Your Ref: OWPC21969
Our Ref: M/24/19/PL 06-03-2019
Please ask for:
Andrew Wood

Replacement residential dwelling. This application may affect a Public Right of Way.

3 The Hard Elmer

REV.	DESCRIPTION	DATE
1	PROJECT REPLACEMENT DWELLING 3 THE HARD ELMER SANDS WEST SUSSEX	
2	CLIENT Ms D HUANG	
3	DRAWING TITLE PROPOSED PLANS, ELEVATIONS & SITE PLAN - DRAFT ISSUE ONLY	
4	SCALE VARIOUS @ A1	DRAWN BY MUM
5	DATE JAN 19	
6	DWG NO PLO1	REV. /

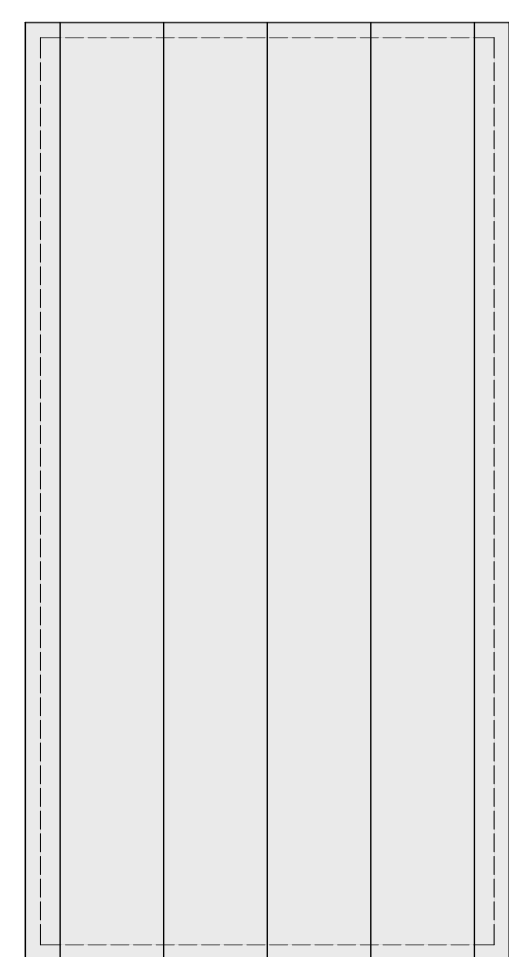
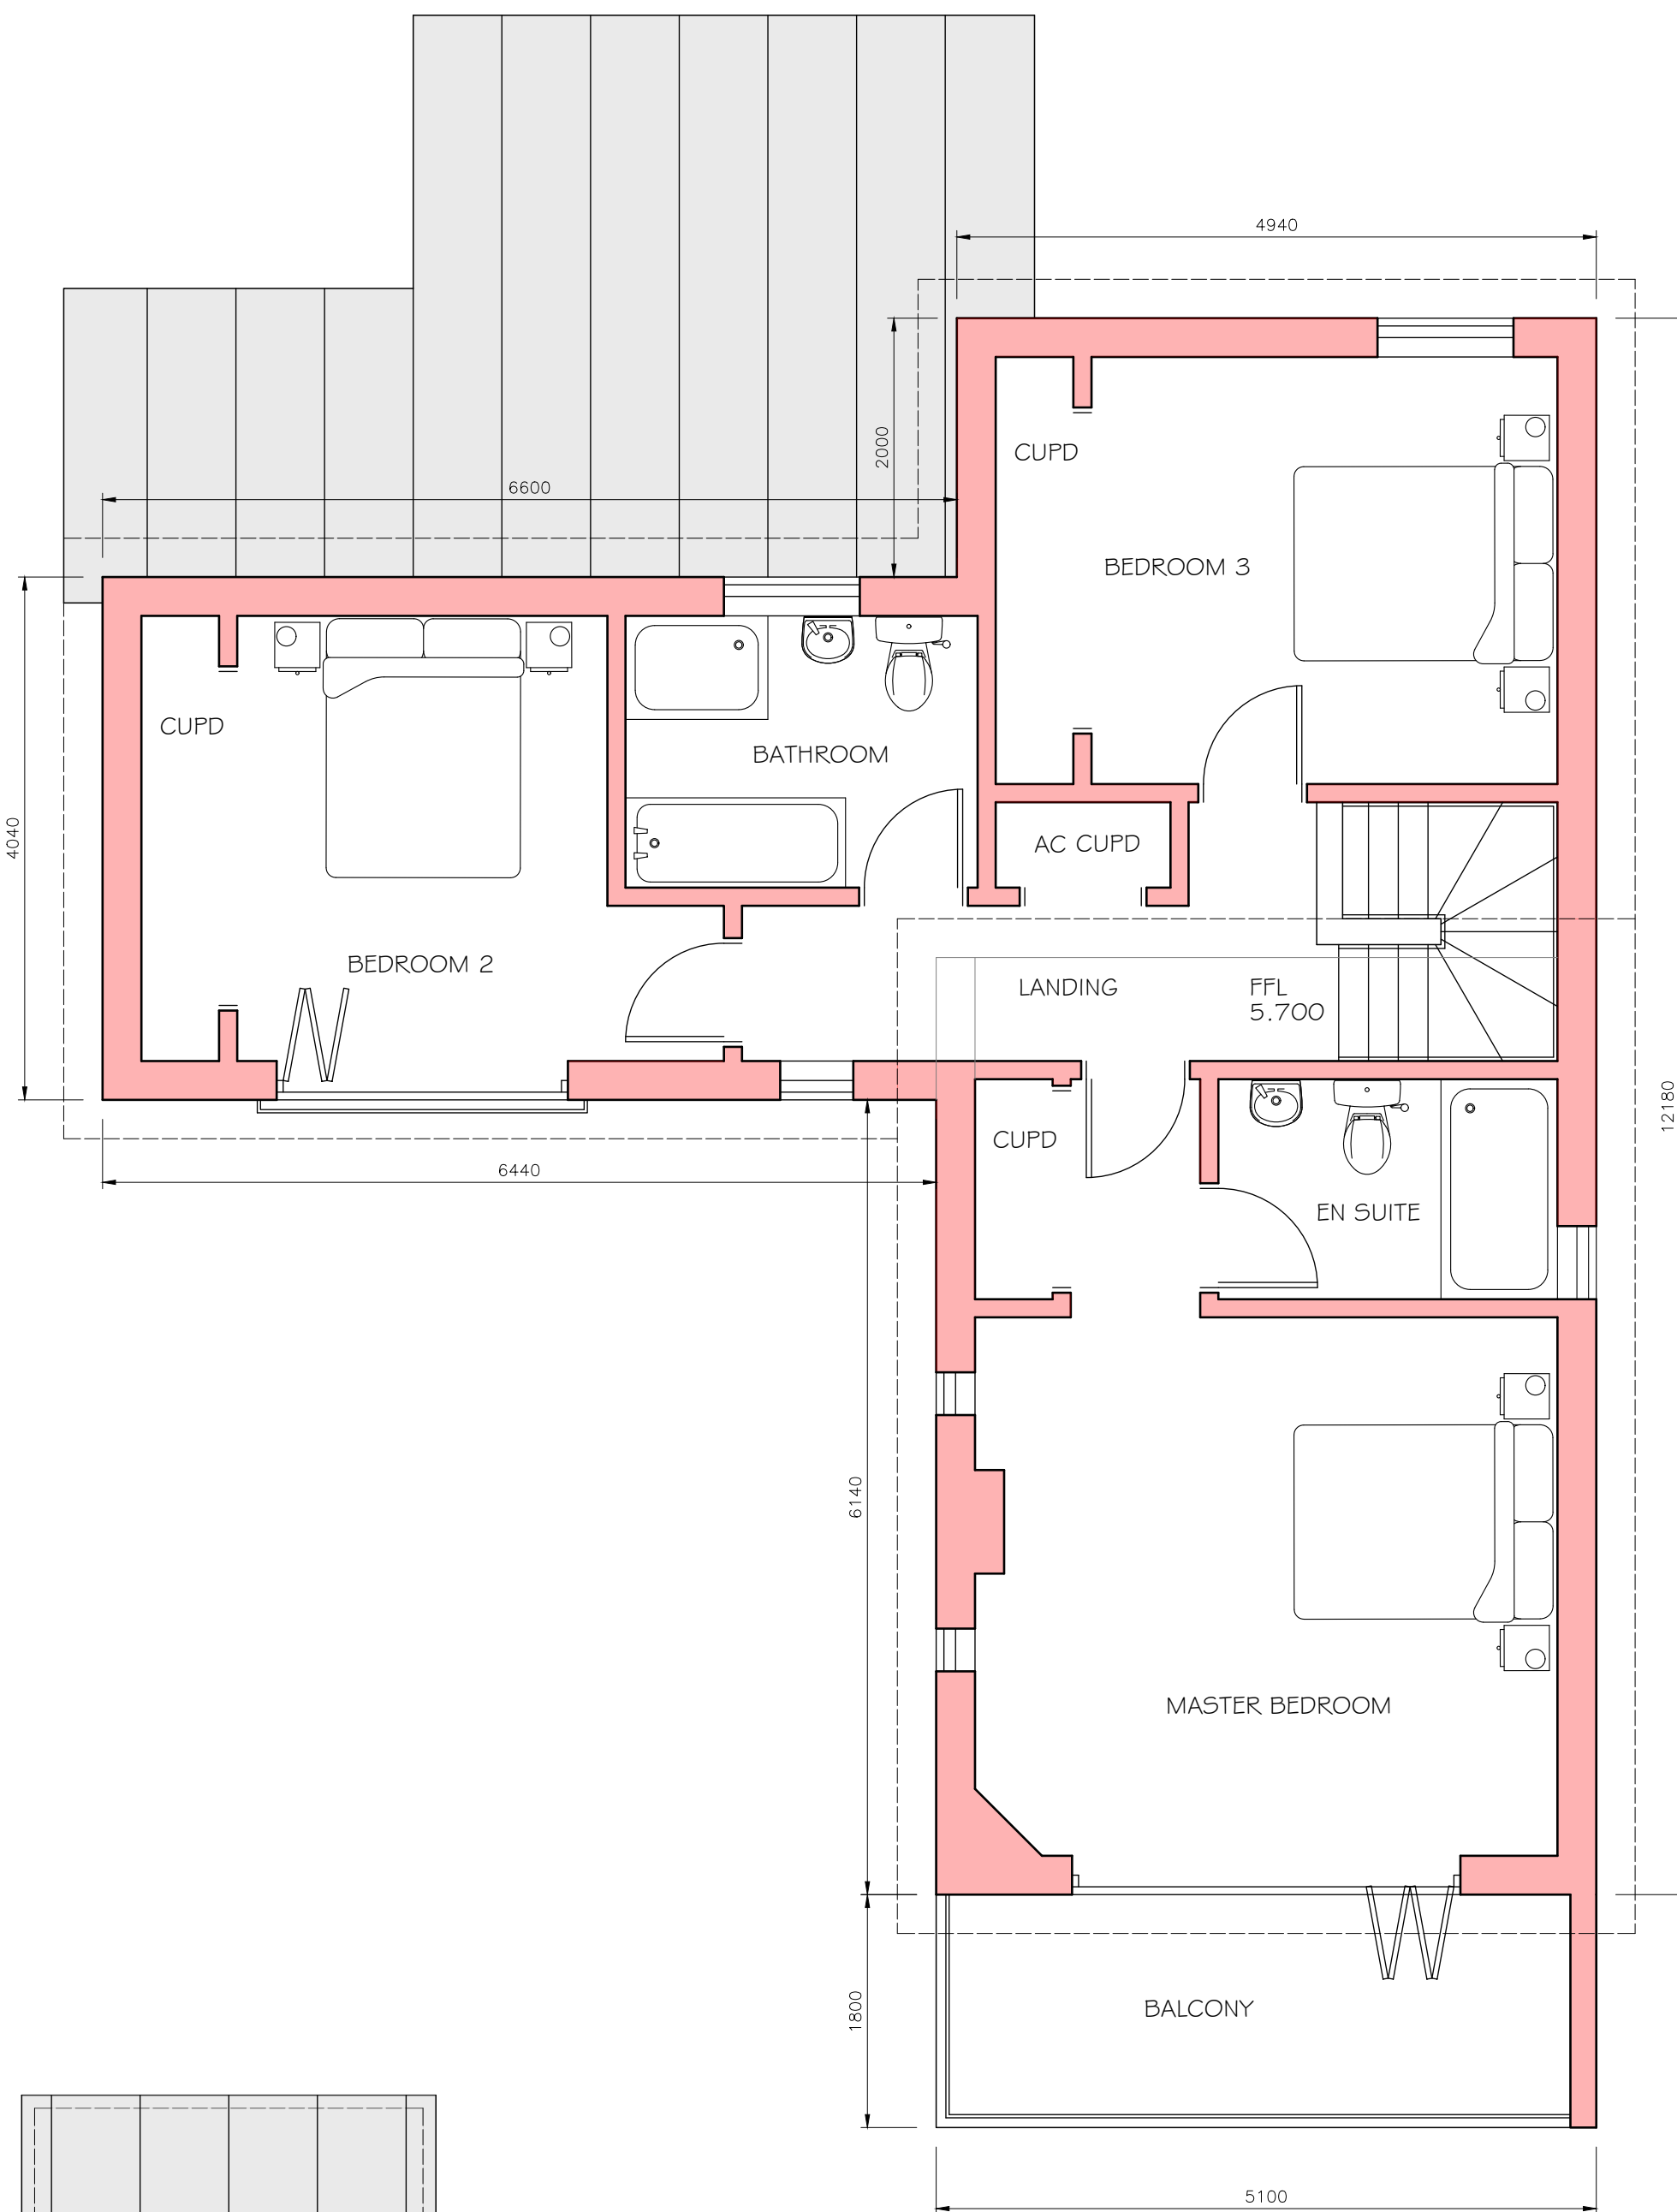
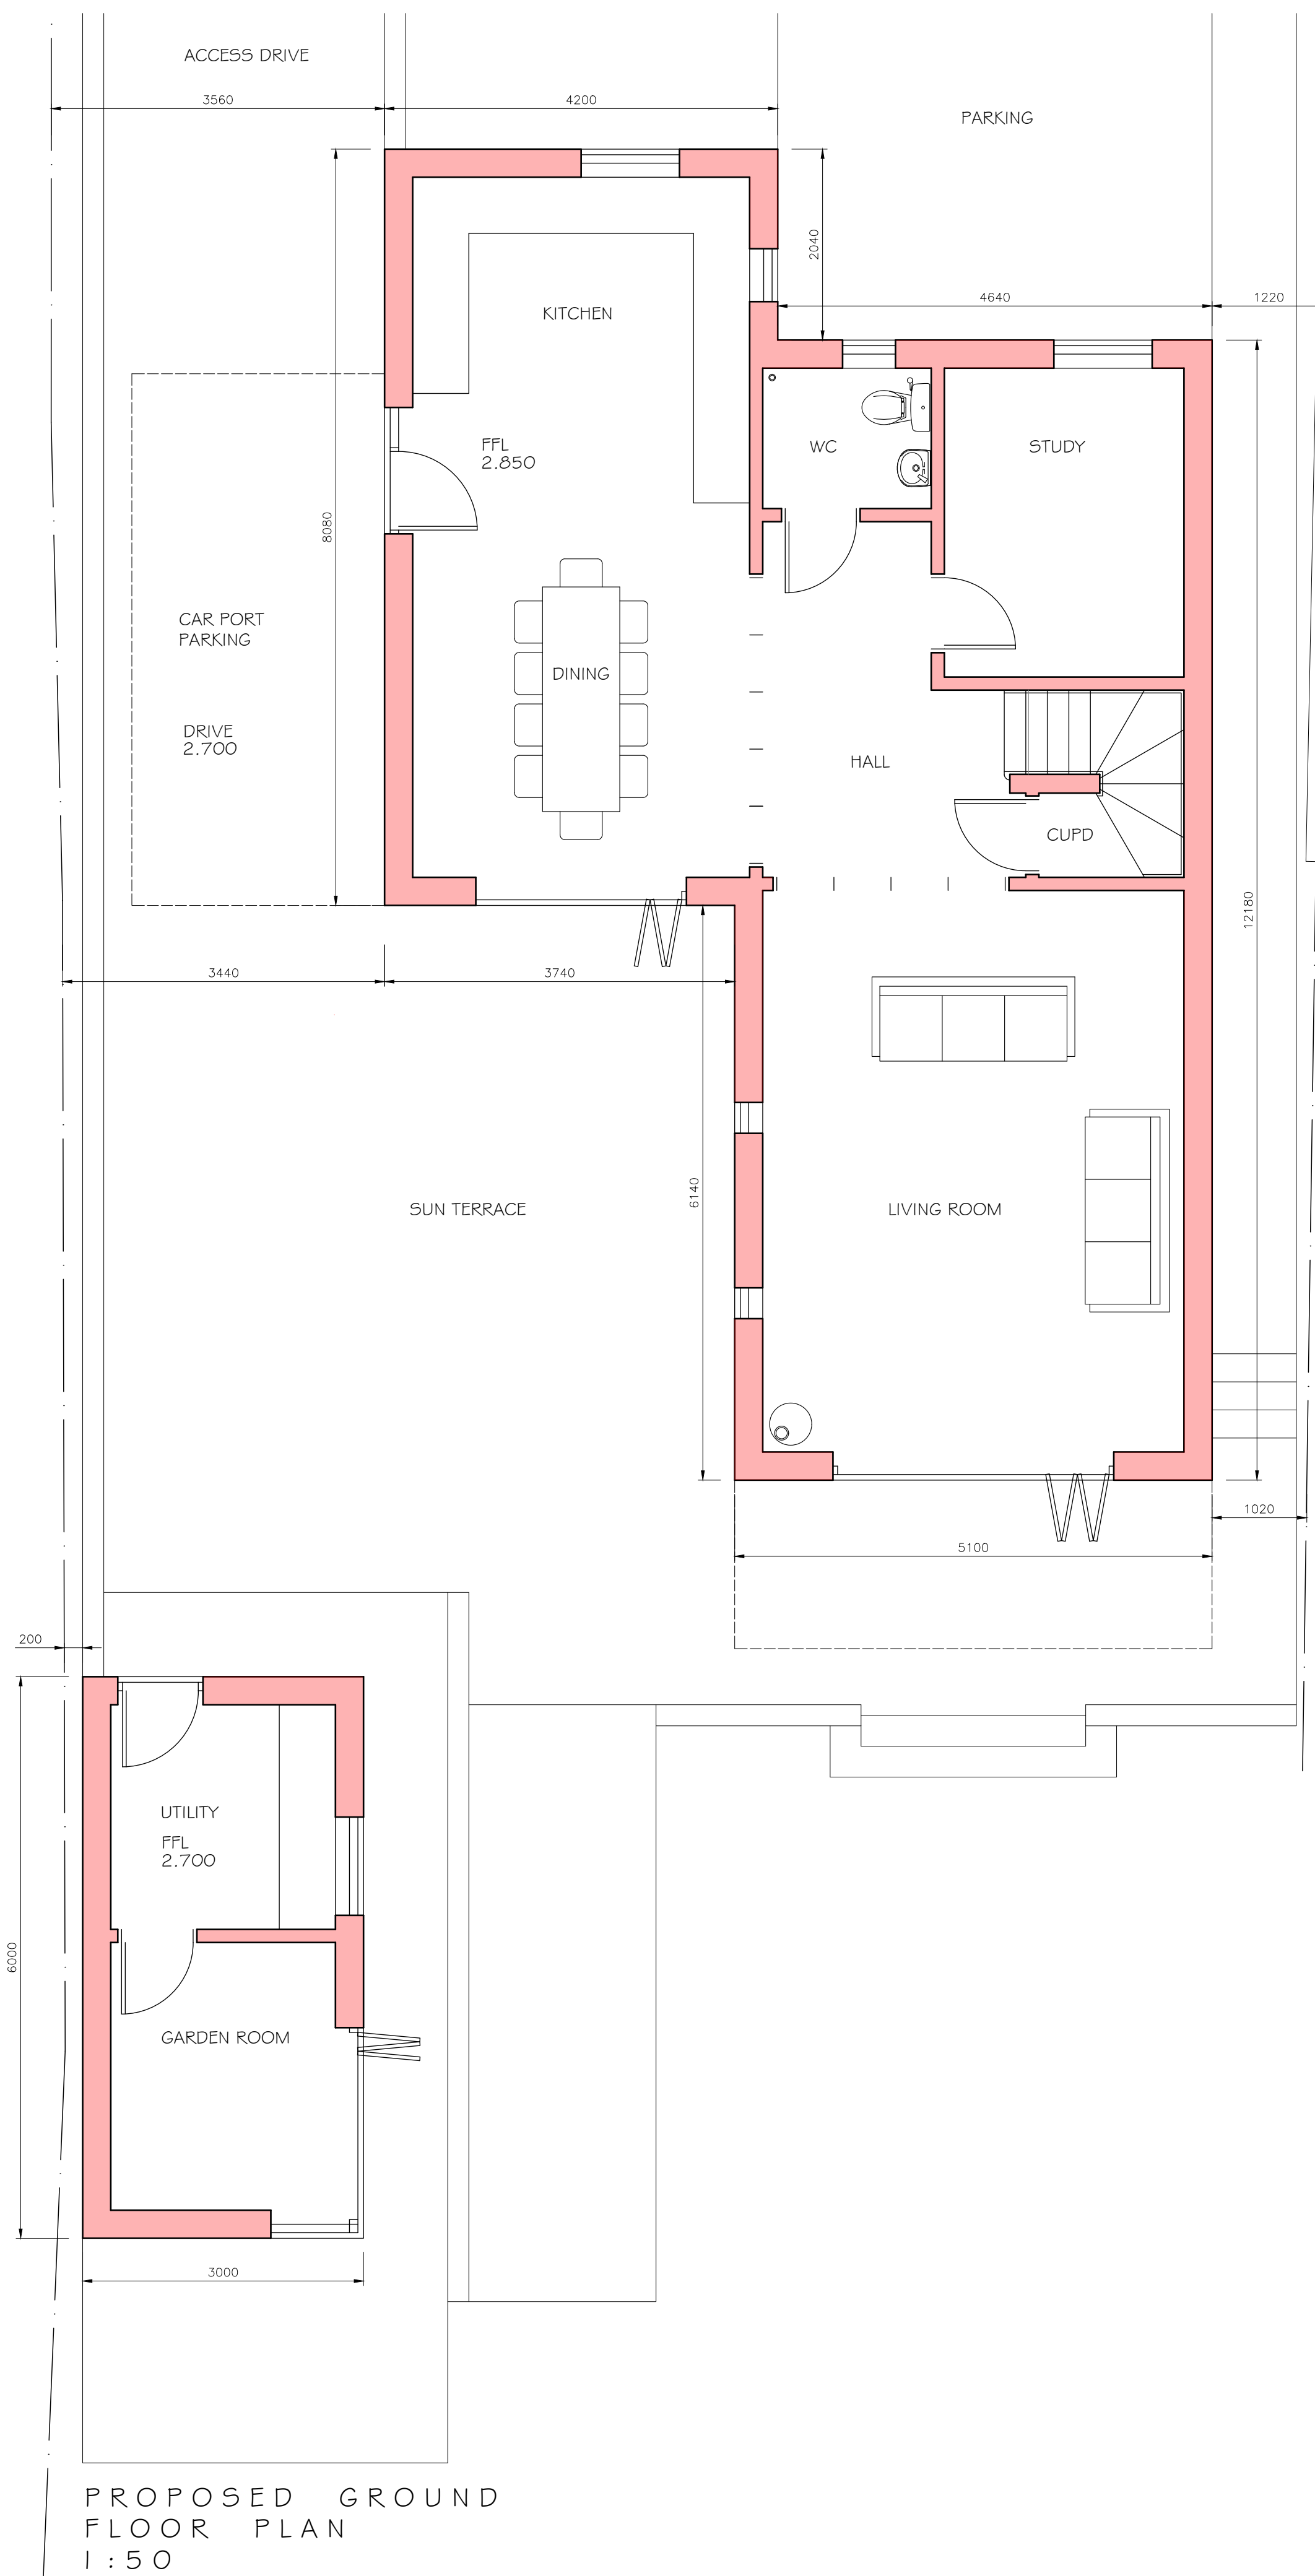
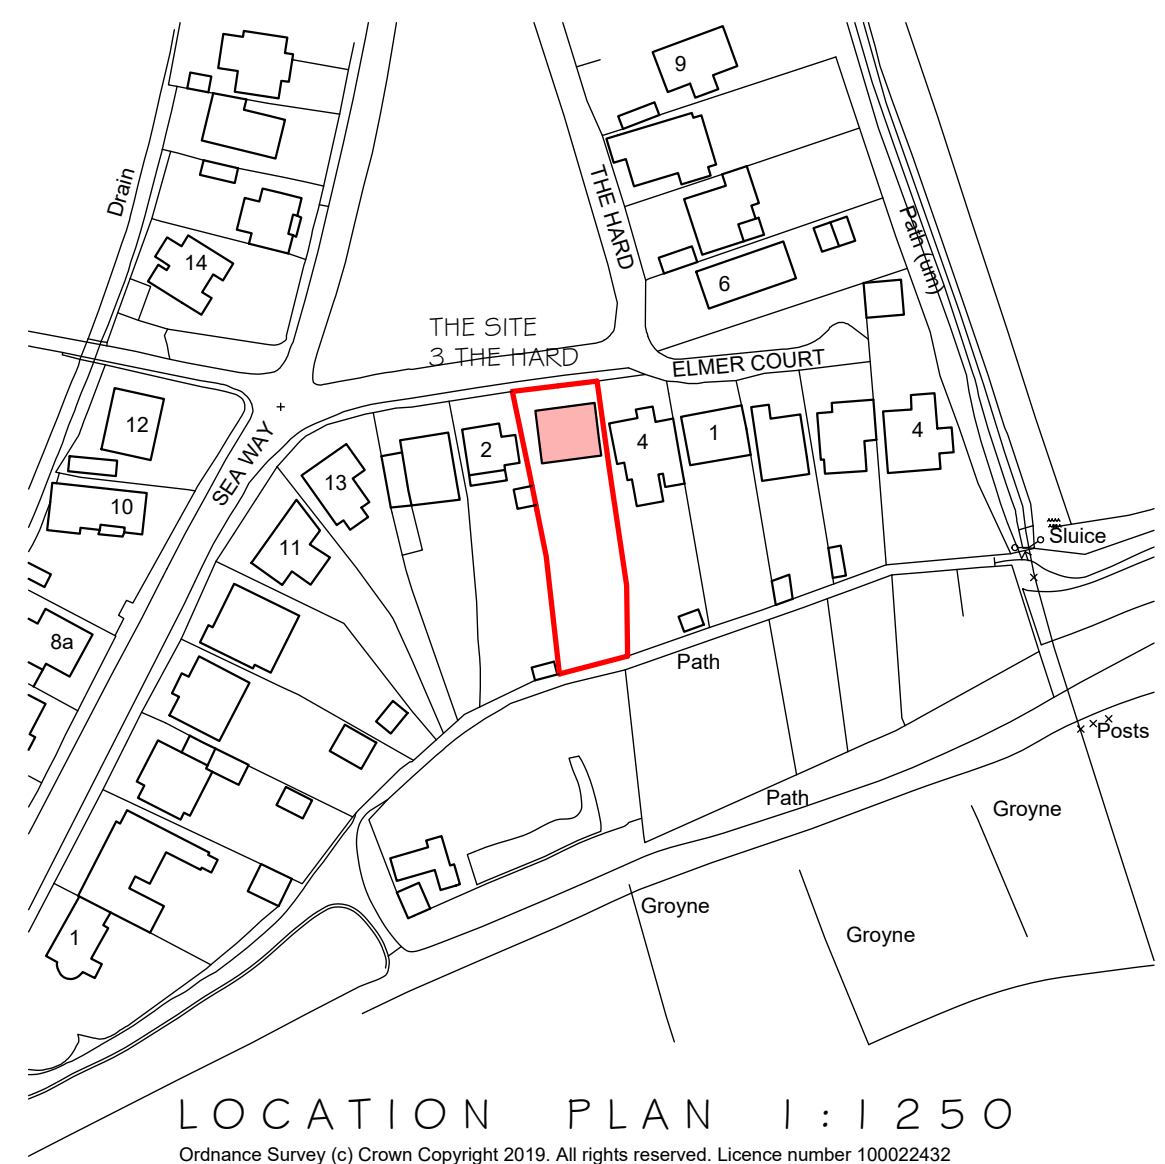
Elmer Sands Limited acts in the interests of the wider membership of the Elmer Sands Estate and as such registers an interest in the issue of the sea defence bund running east to west through the garden of 3 The Hard and adjoining properties. The plans show a reduction in height of this bund, possibly levelling? This forms a long standing second defence of sea ingress in the event of over-topping of the primary beach sea defence and as such it is a second line of defence to sea ingress generally across the estate.

Whilst changes have been made to the sea defences over the years a breach remains a current possibility, certainly before improved sea defences are delivered hopefully later this year. As a result ESL would not favour a reduction in this secondary defence before a proper assessment has been carried out and the Environment Agency has confirmed its obsolescence.

This aspect may be incidental to the general building consent but if planning permission is approved it is suggested that a condition be included that this issue is investigated prior to any agreement to reduce the height of this bund.
